Interlaken Engineering and Design, PLLC  
7001 Seaview Ave NW, Suite 160-388,  
Seattle, WA 98117 | (206) 470-9572

June 28, 2021

RE: 80XX SE 20<sup>th</sup> Street (Parcel 544930-0057)

Please find changes between the initial submittal dated March 22, 2021 and the updated submittal dated April 30, 2021 outlined below:

**C2**  
Drainage Site Plan  
Scale: 1" = 10'

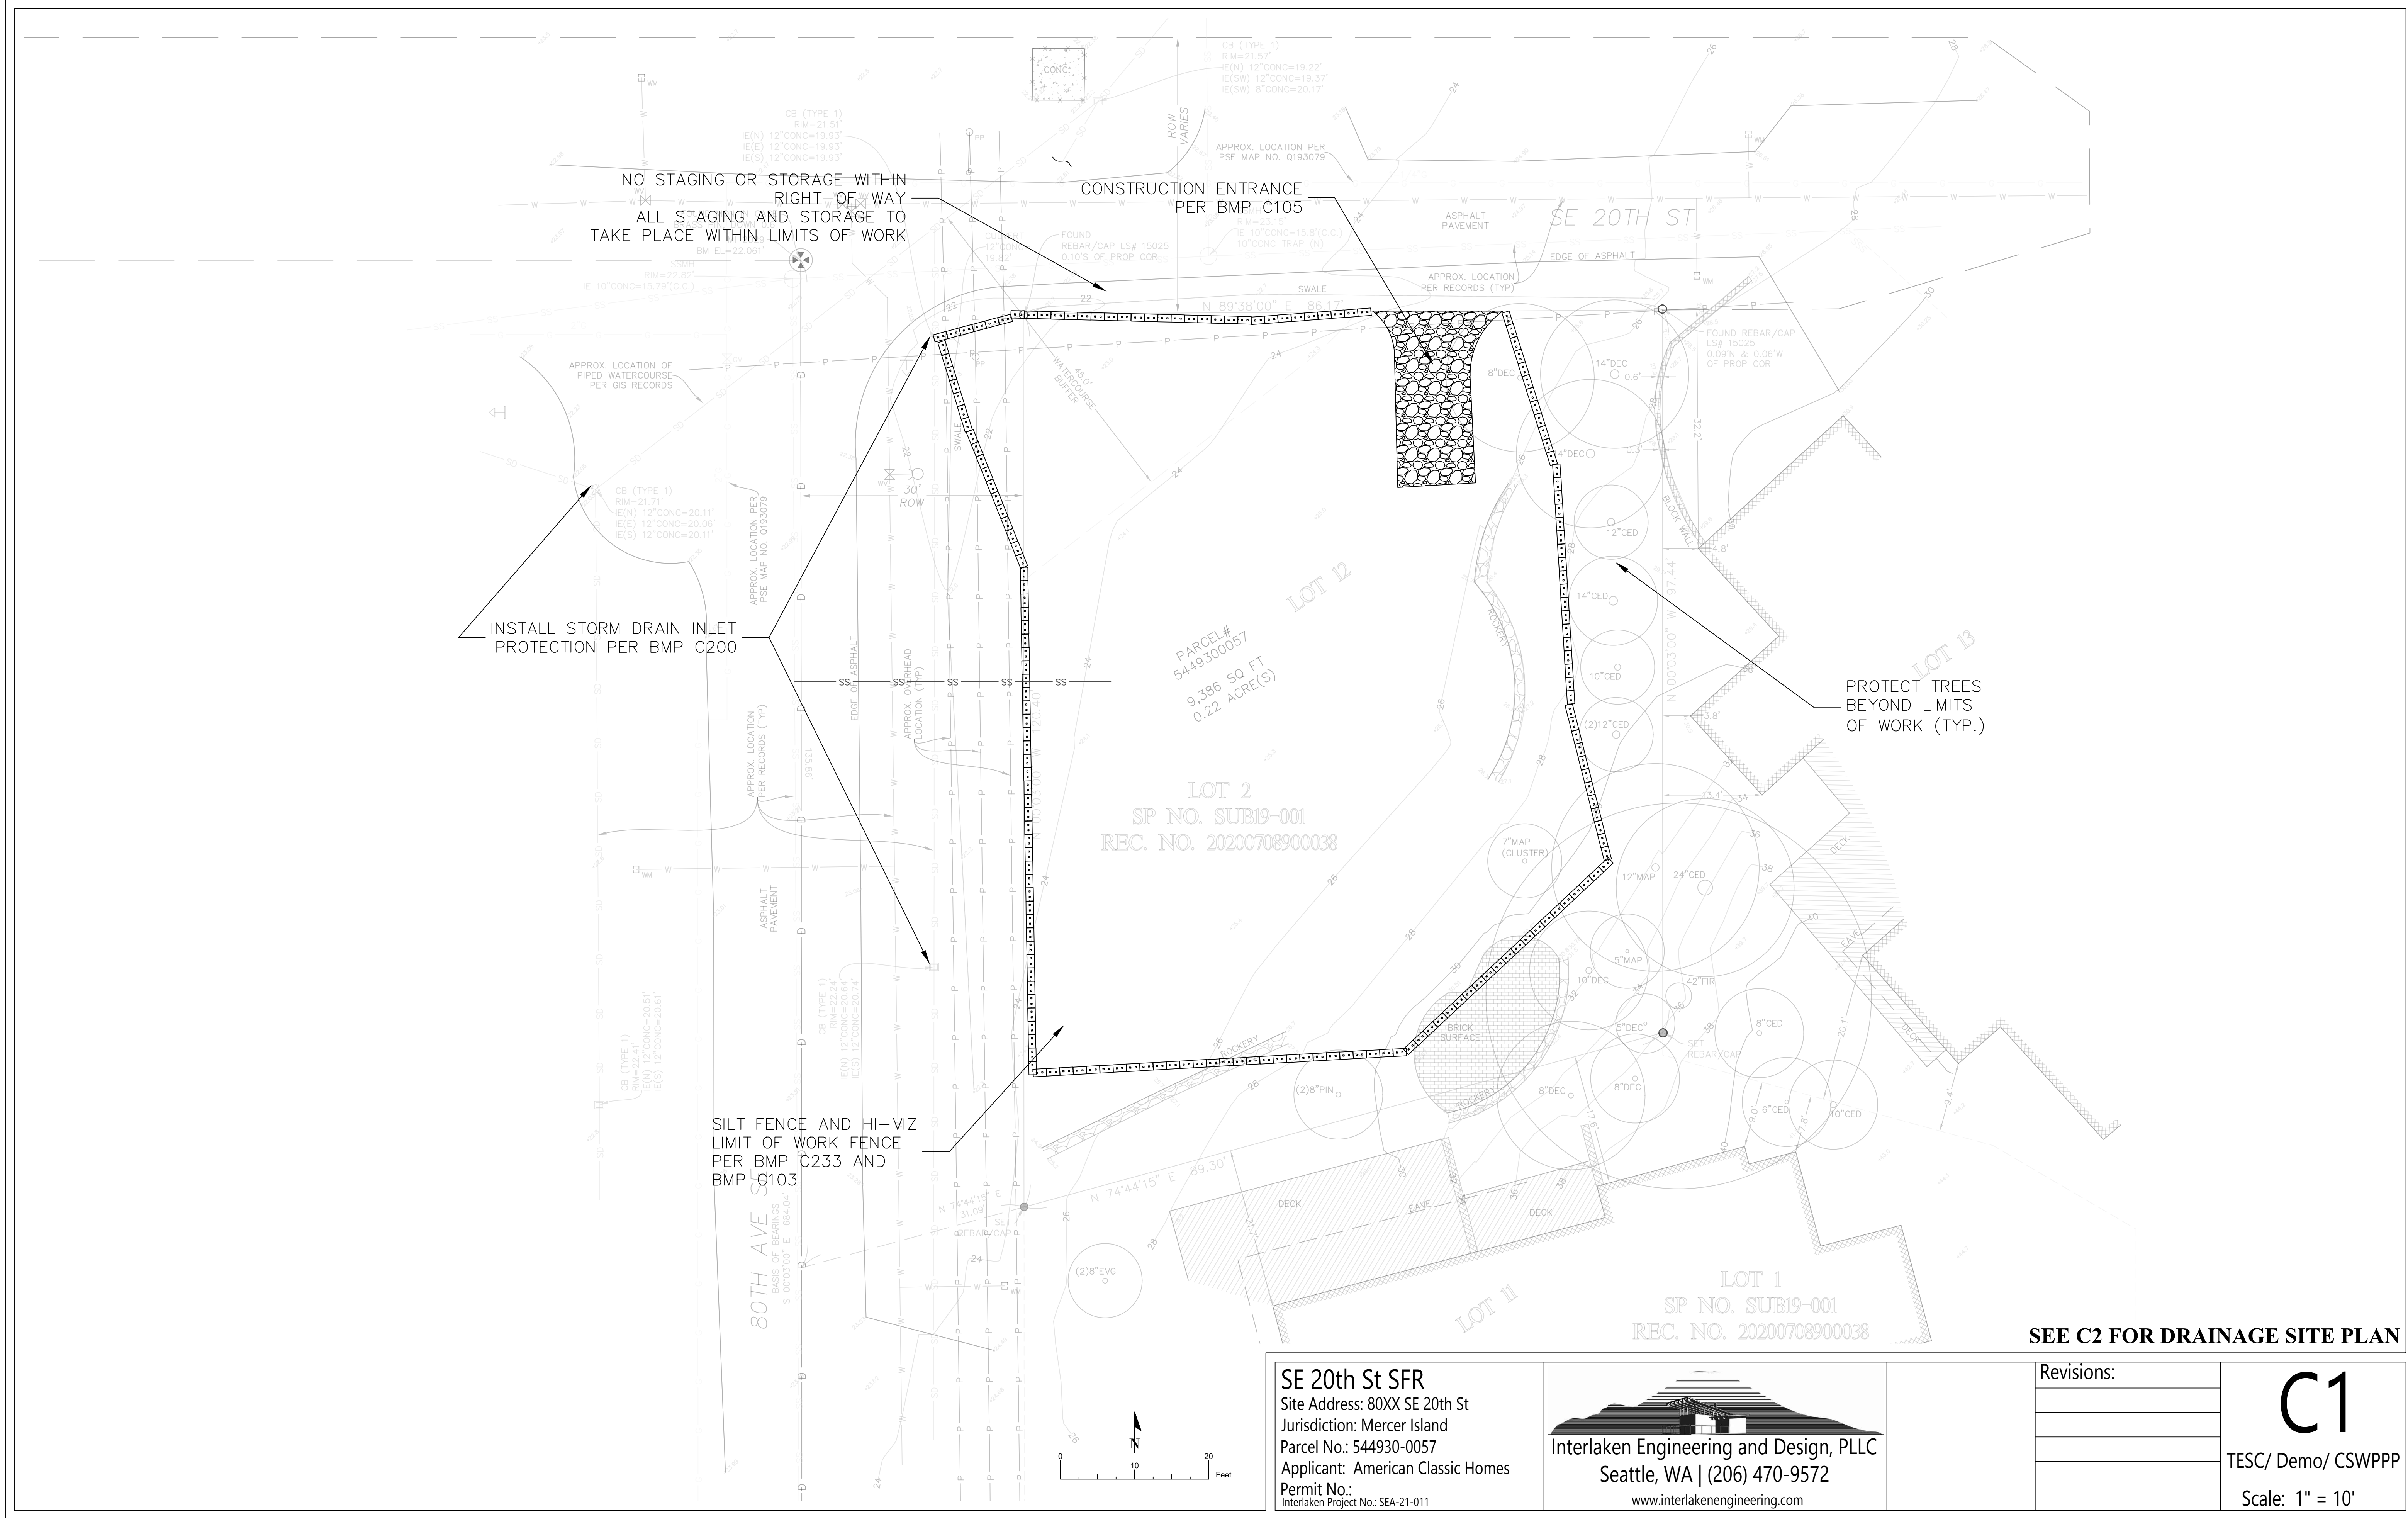
- 1) In response to the capacity constraint of the downstream storm drain a detention system has been added, as shown on Sheet C2, detailed on Sheet C3, and indicated on page 5 of the Stormwater Submittal.
- 2) Downspouts re-routed around house, as shown in sheet C2.
